Ref; 2025/1077

With regard to: Change of use of the Dwellinghouse and former Ship Inn Public House, from (Class C3) to 4-bed 4-person HMO (Class C4) (Amended Description)..

Location: 329 Midland Road, Royston, Barnsley, S71 4AZ

Thank you for giving South Yorkshire Police 'Designing Out Crime Officers' the opportunity to review this planning application.

Drawing SCHEME PROPOSAL  
EXISTING AND PROPOSED FLOOR LAYOUTS Drawing No. P.100

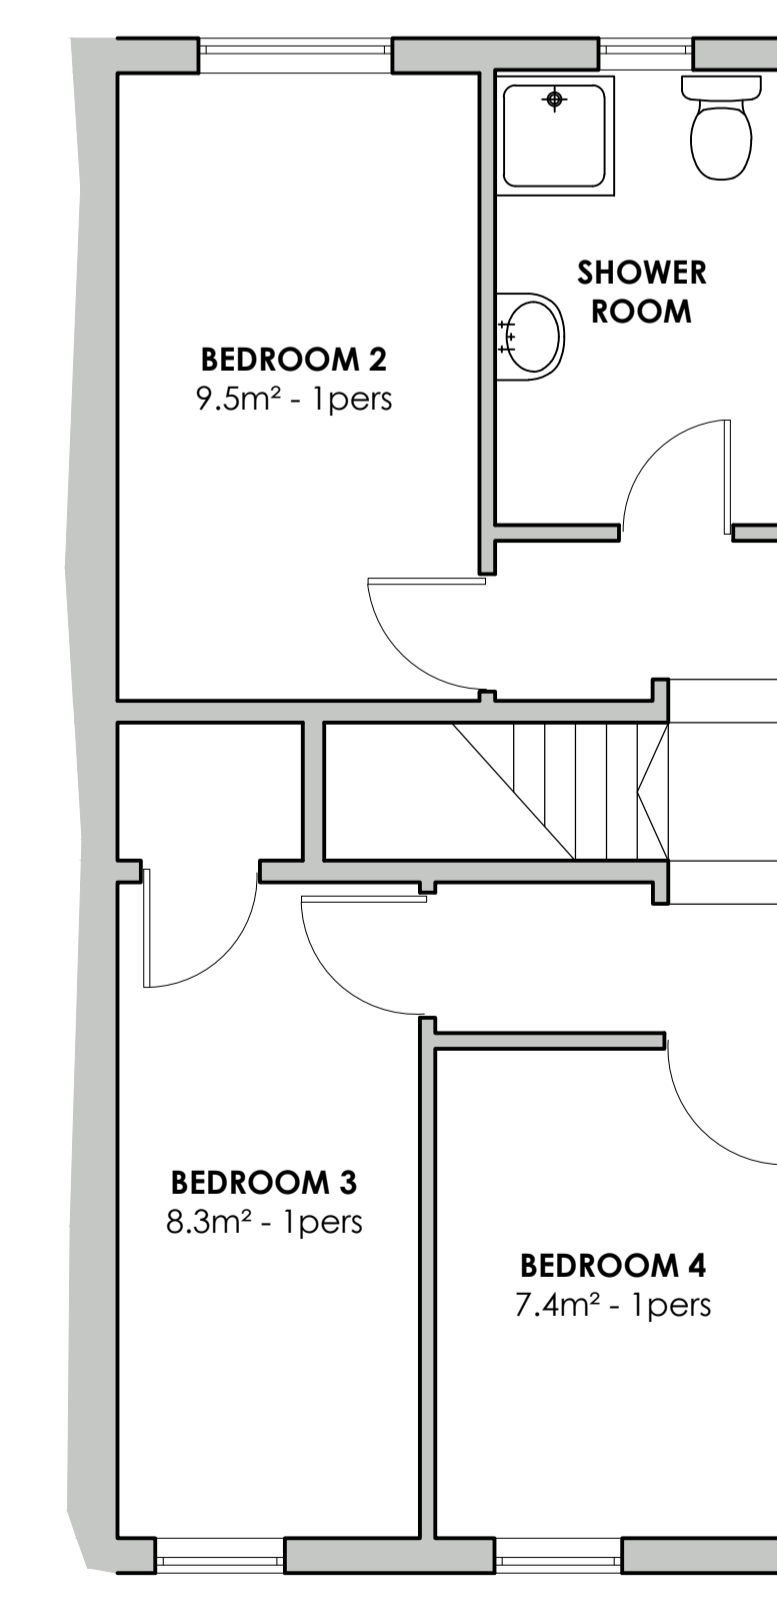
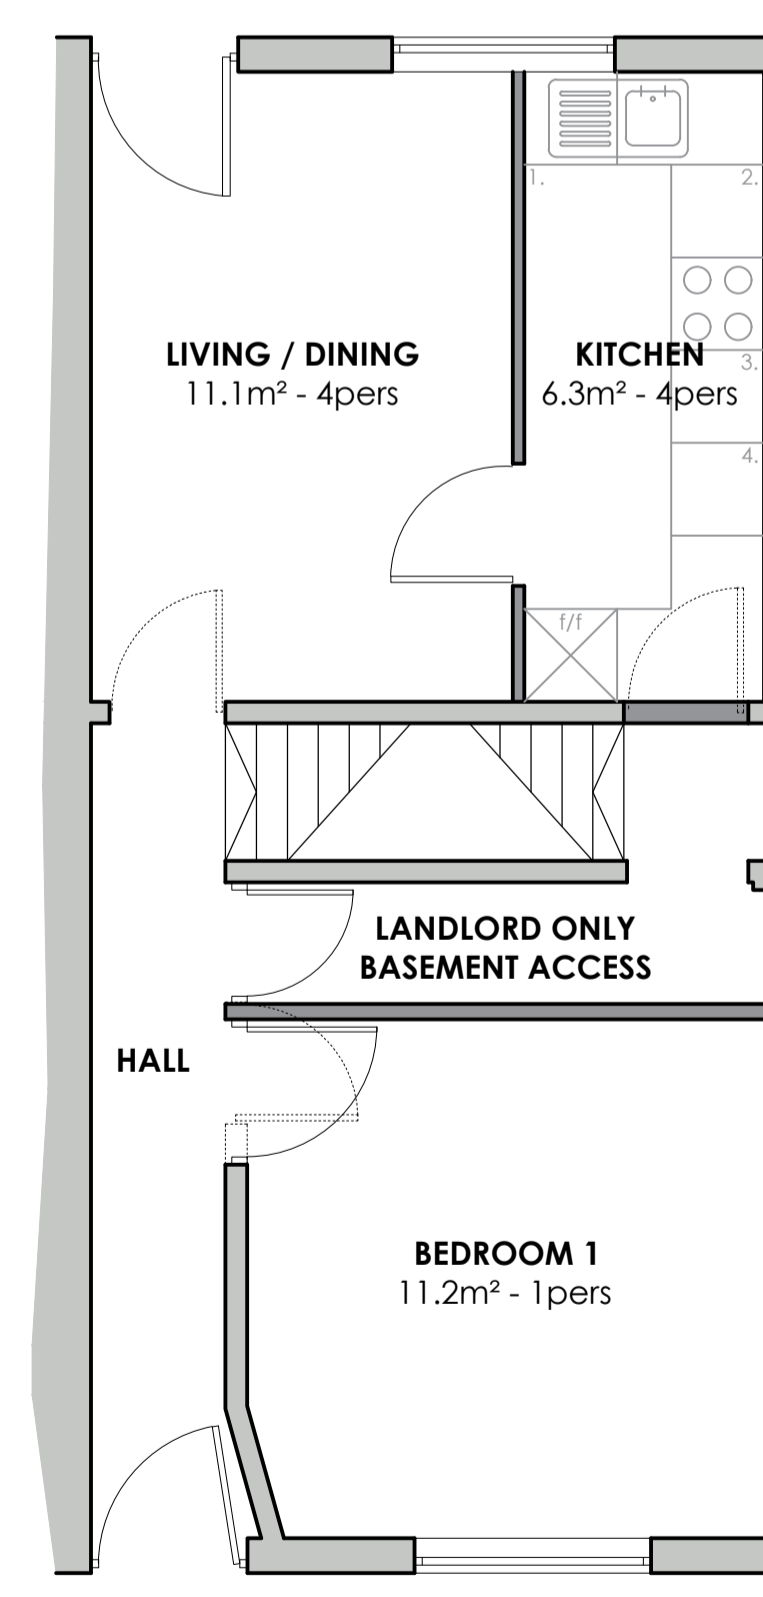
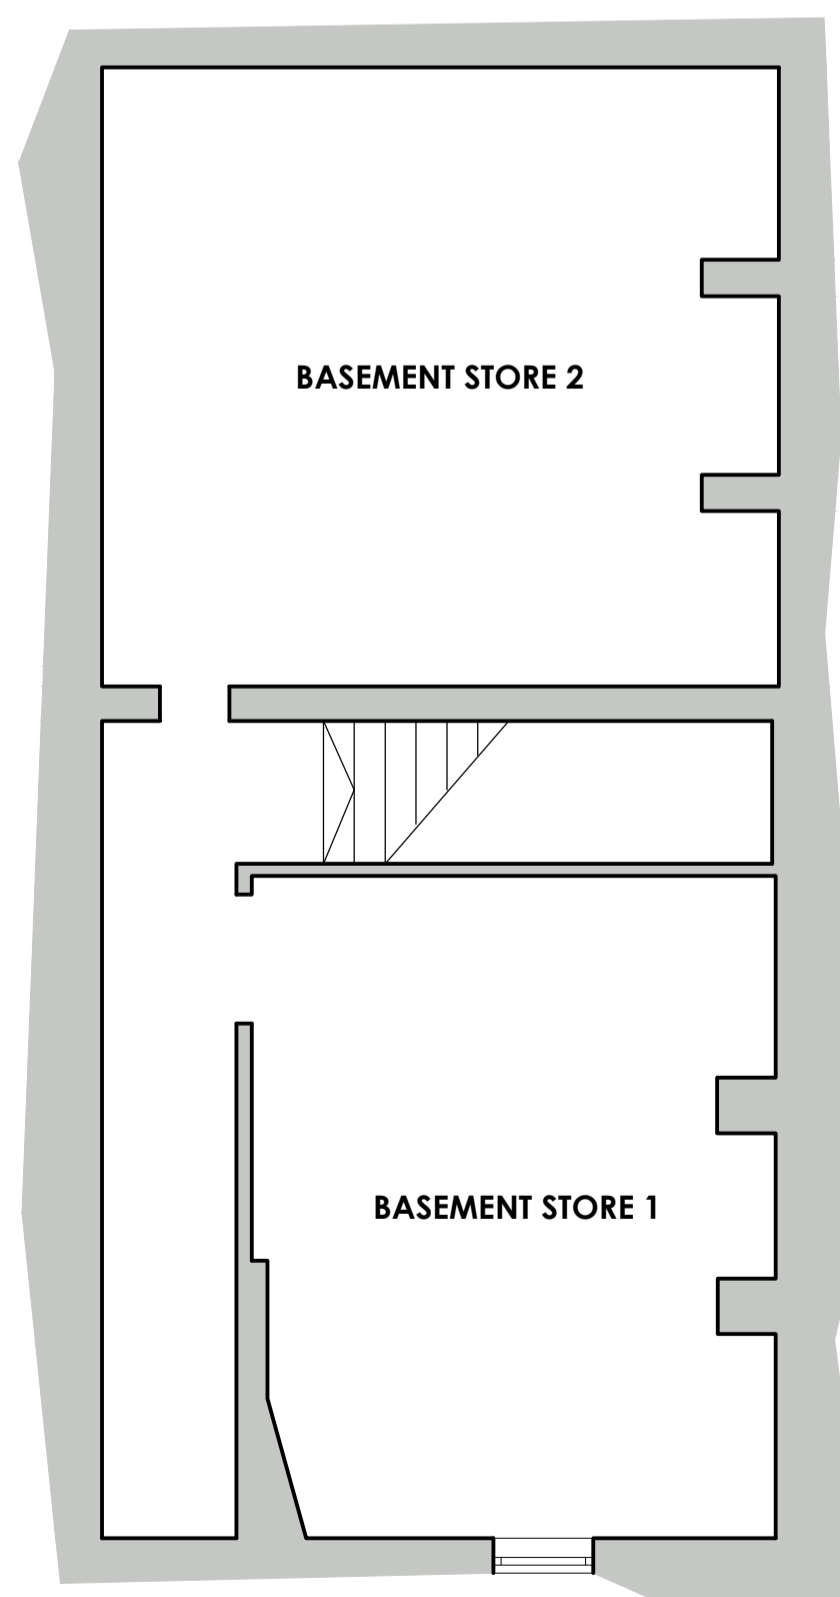
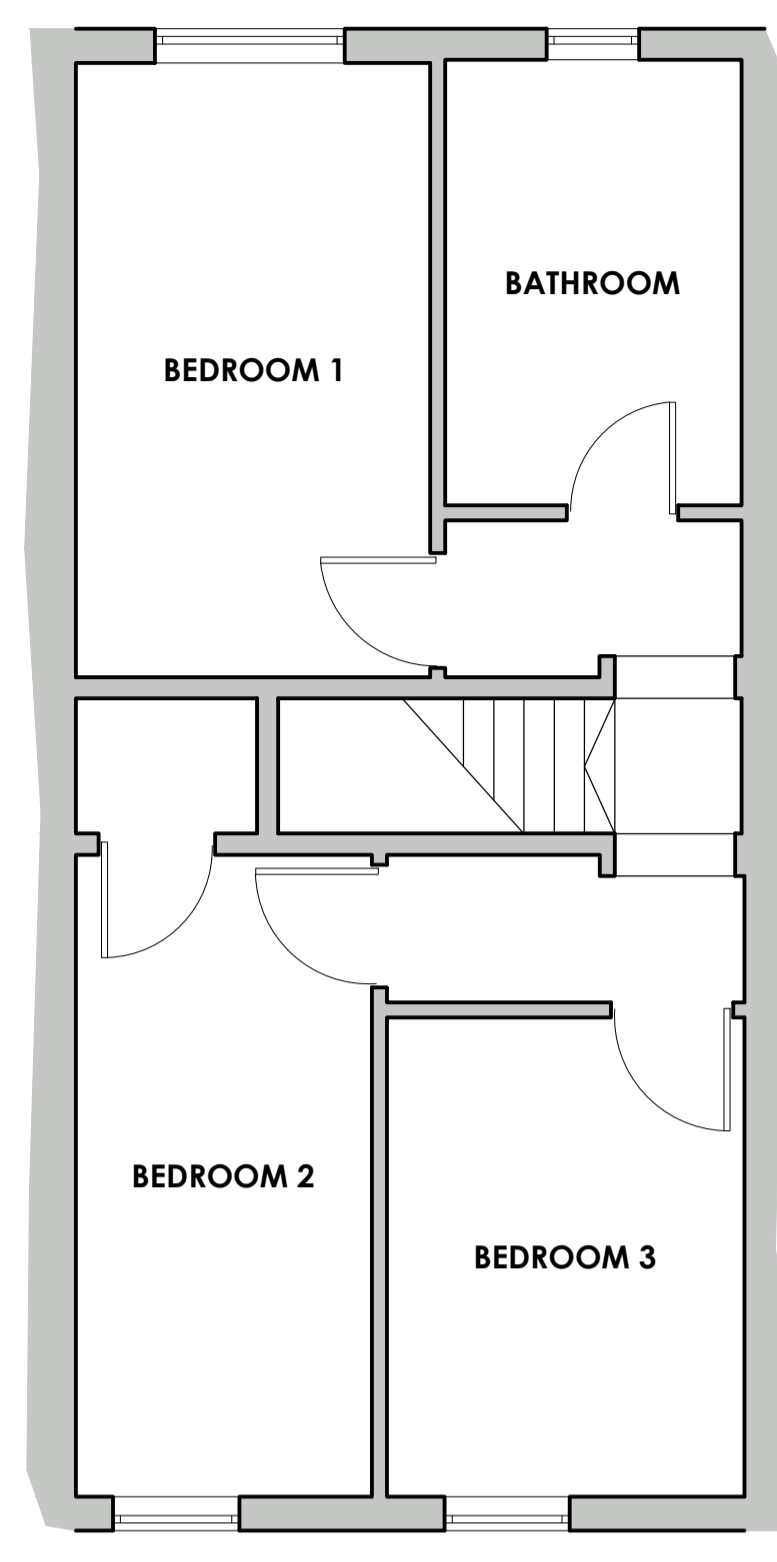
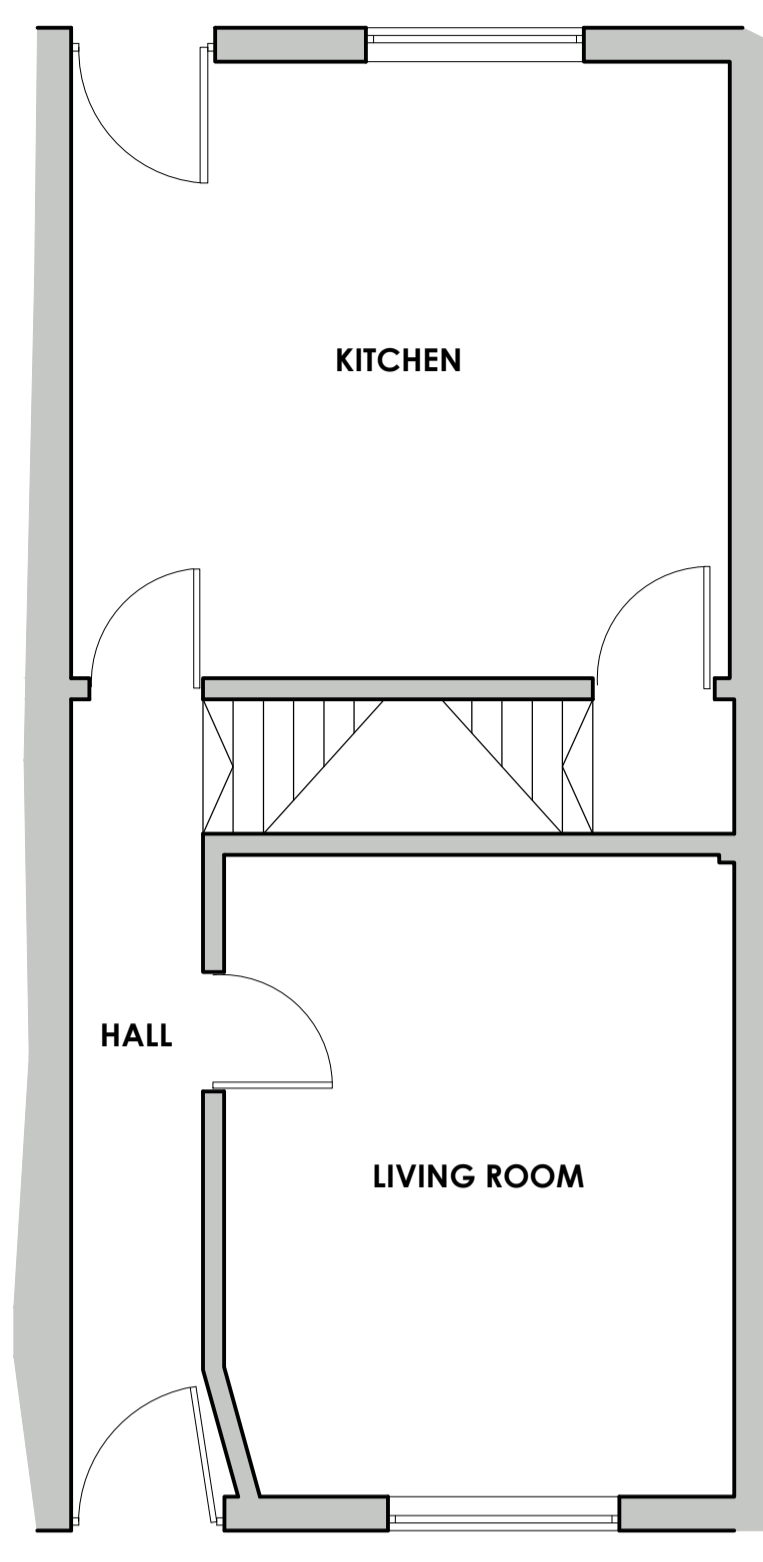
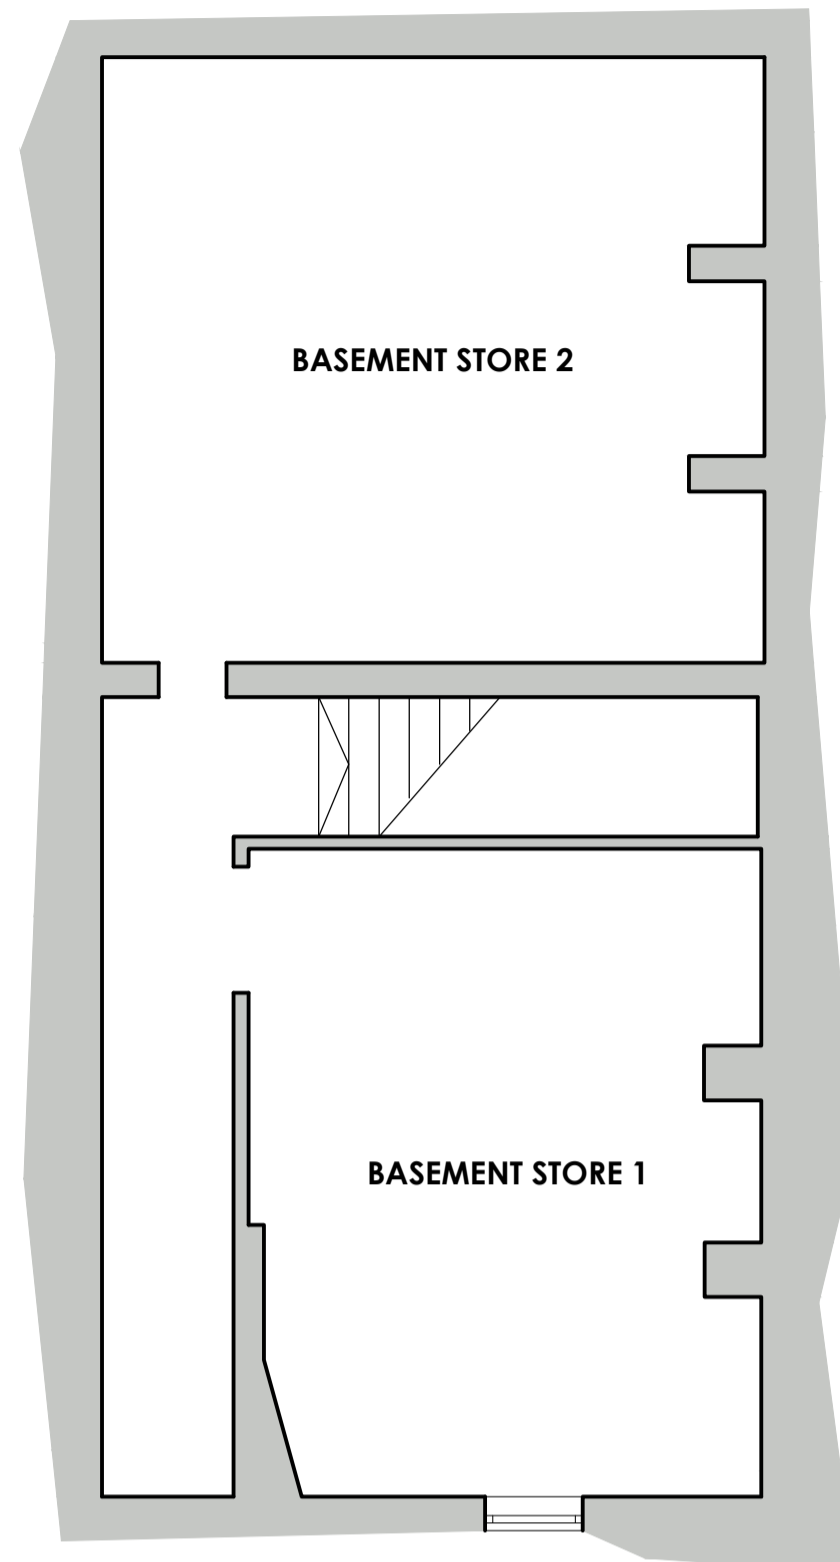
It is crucial that the main entrance door to a HMO MUST NOT be fitted with a lock that is operated by a key on the inside, this could allow residents to inadvertently lock other residents out.

Ideally, older entrance doors should be replaced with doors that have achieved PAS 24, and that have achieved dual certification with regard to both fire and security, these doors must have the ability to open from the inside with a single keyless action.

With regard to the internal entrance doors. They should all be fitted with doors that have achieved PAS 24 dual certification for both Q-Mark Fire Door and Q-Mark Enhanced Security.

Access control and additional Visitor door entry systems shall be easy to operate and understand and have the ability to display the image of the caller before the call is answered so the resident can choose whether to answer the call or not.

This will allow the occupant of the dwelling to remotely operate the electric locking device from their room terminal, thereby unlocking the communal entrance door(s) associated with the action and allowing the visitor access.
